Our Ref: EG/7/19/PL

**Town & Country Planning Act 1990 (as amended)
Town and Country Planning (Development Management Procedure) (England) Order 2015
Application for Planning Permission**

Development Demolition of existing detached dwelling & garage & erection of 1 No. dwelling with car port.

Location 26 Downview Road Barnham

proposed site plan 1:250

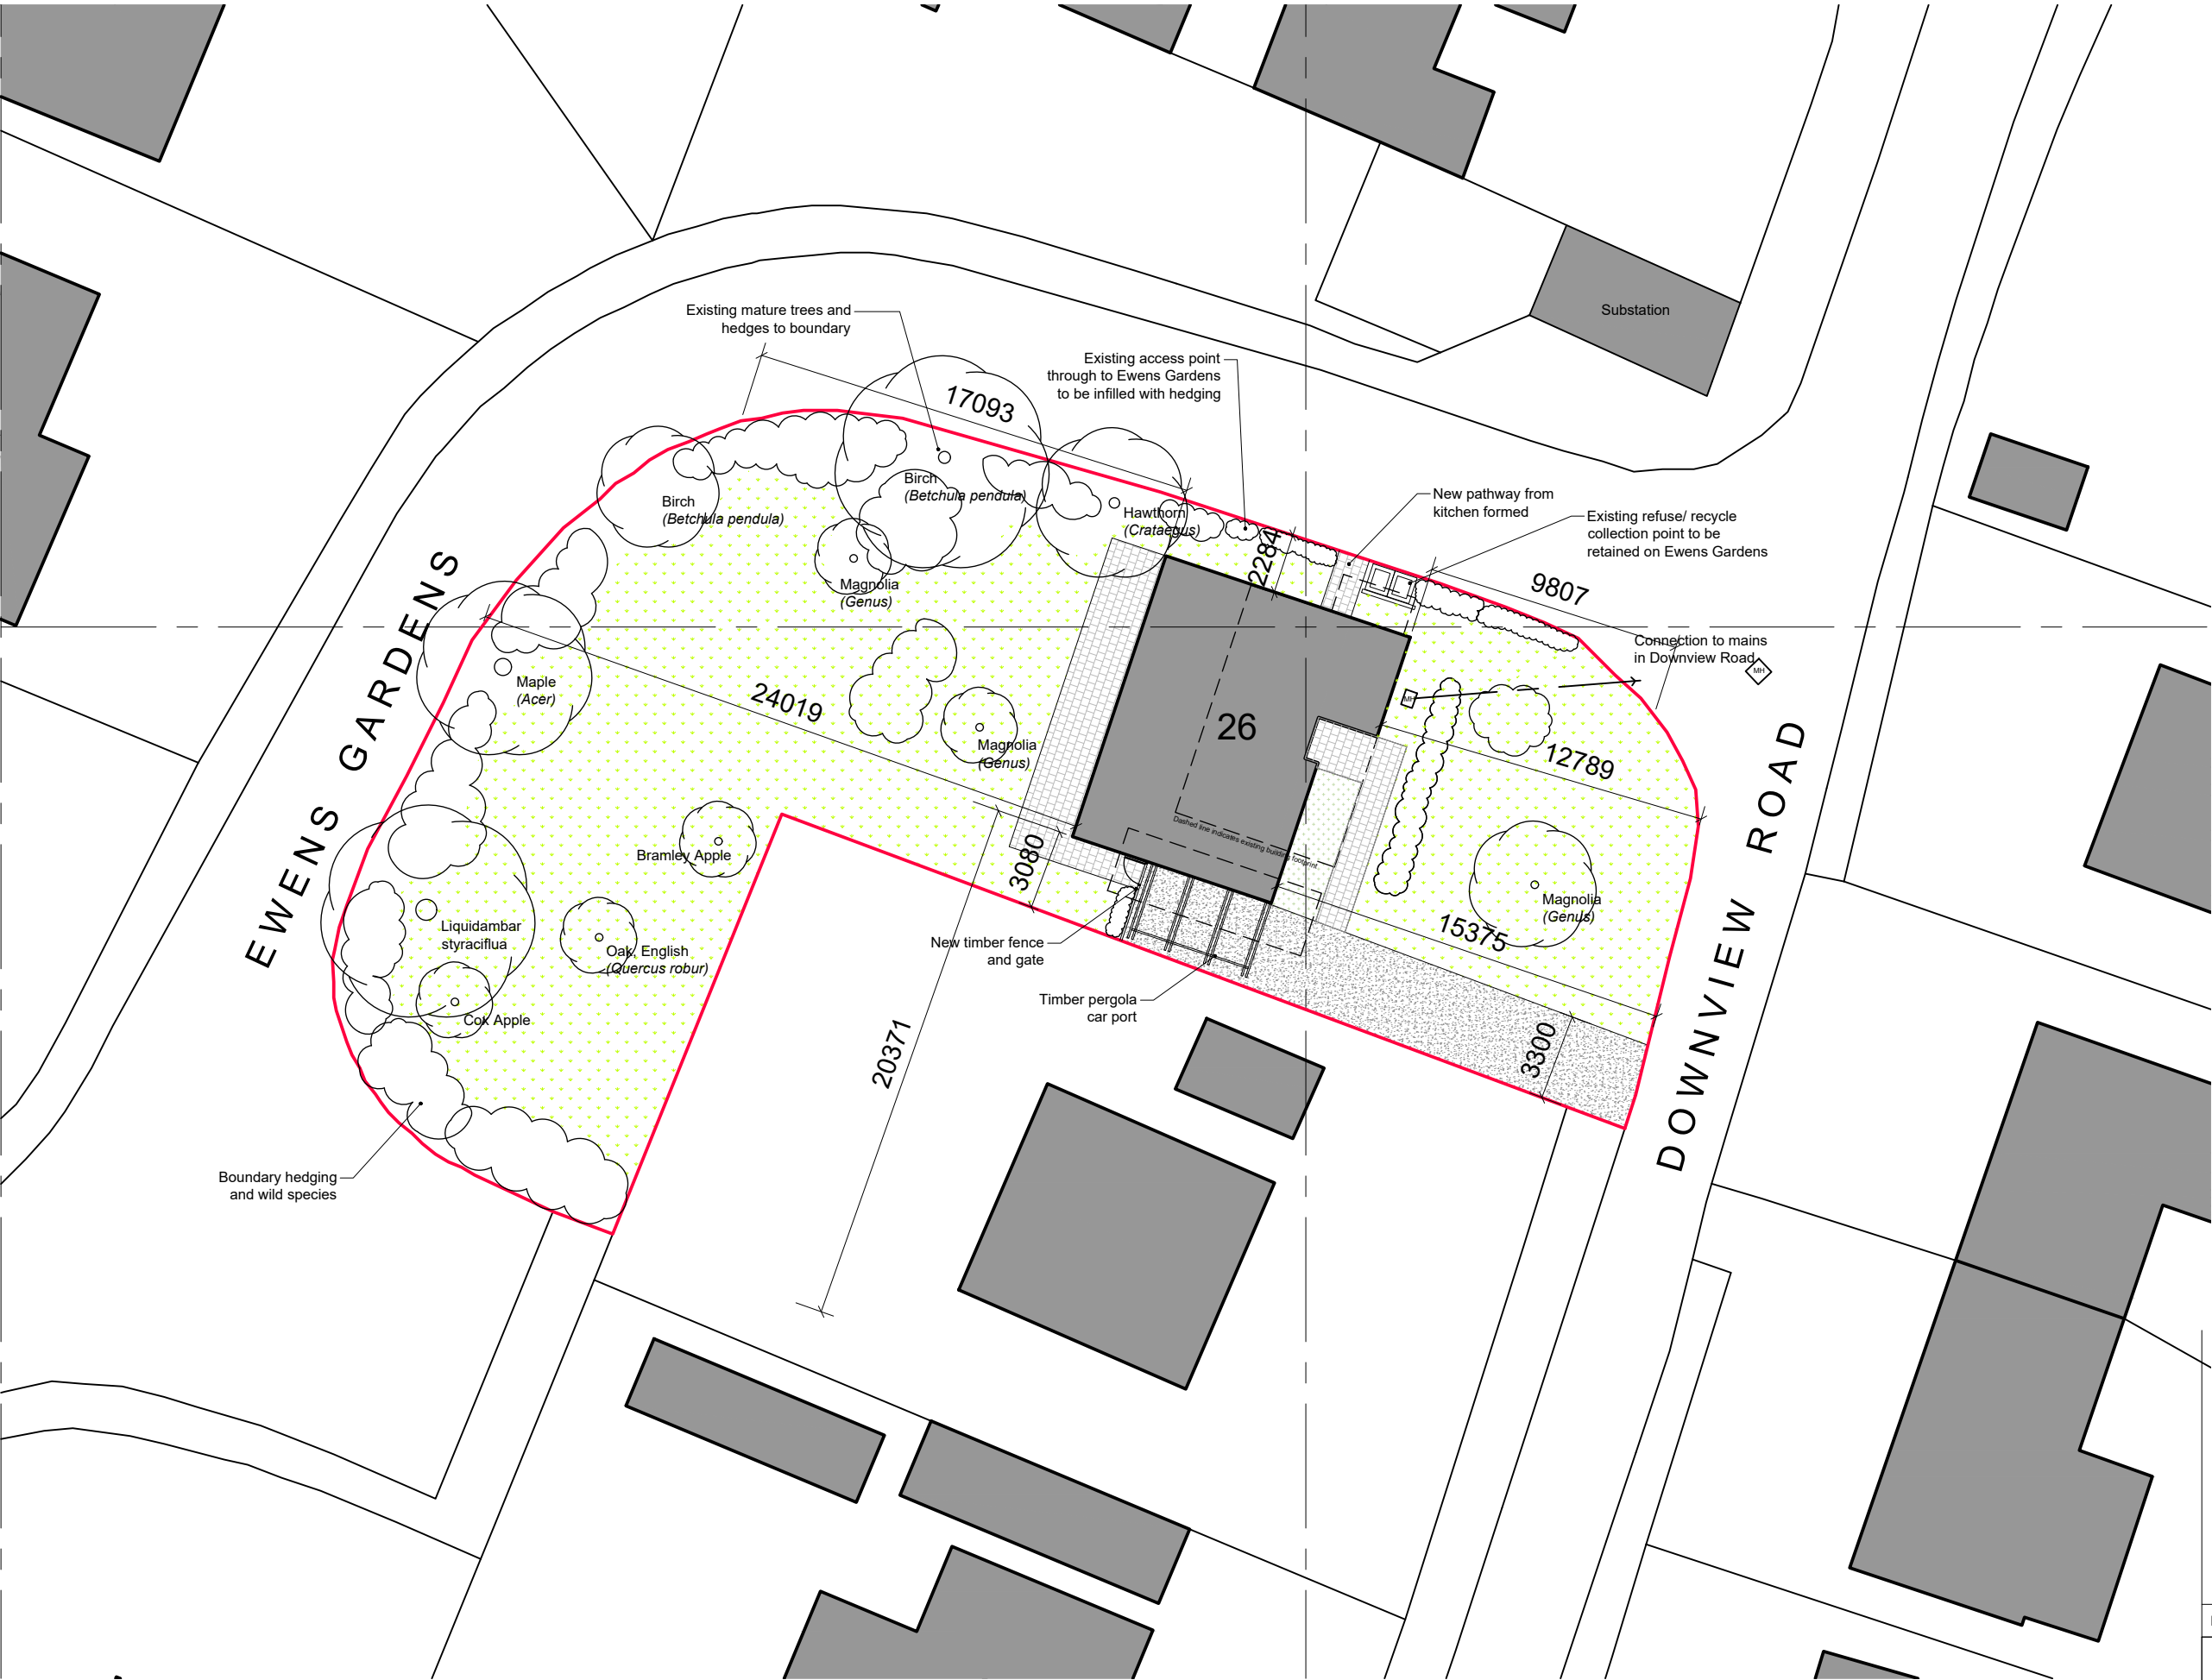
Proposed Block Plan Amend

Please provide measurements from the proposal to each boundary.
